CONVERSION OF FORMER CAR REPAIR WORKSHOP TO ANCILLARY ACCOMMODATION TO CHEVINGTON LODGE FARMHOUSE AND INSTALLATION OF PV PANELS TO ROOF OF STORE

Please find attached our Section 73 Application for the above site together with copies of our drawings numbered 4565-01A, 02A, 03A & 04A.

We obtained a Planning Approval for the works dated 28th September 2023, reference DC/23/0517/FUL.

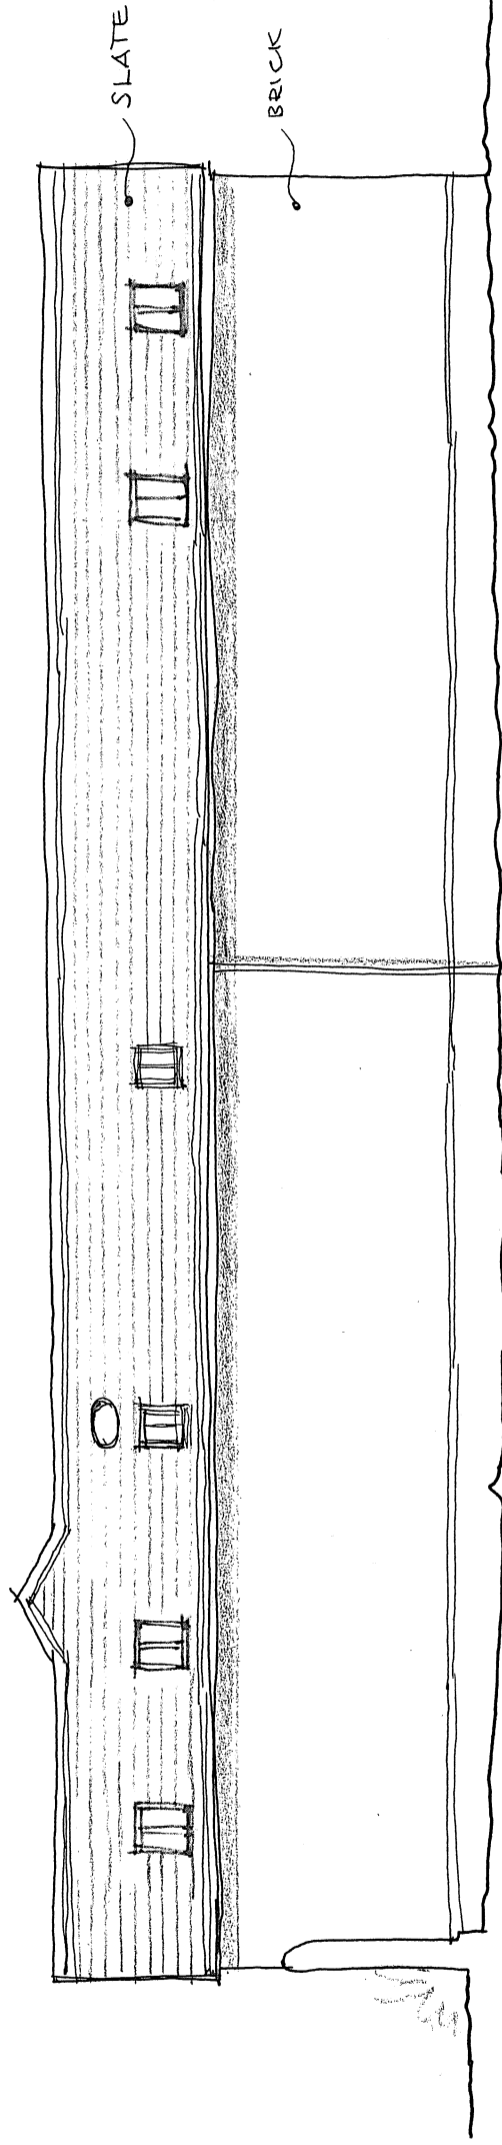
The Application involves a small number of additional, high level roof lights on the west elevation and the inclusion of a projecting lucam style feature on the east elevation together with adjustments to ground levels on this side. These small changes will give our clients the opportunity to install a modest mezzanine floor in the Games Room.
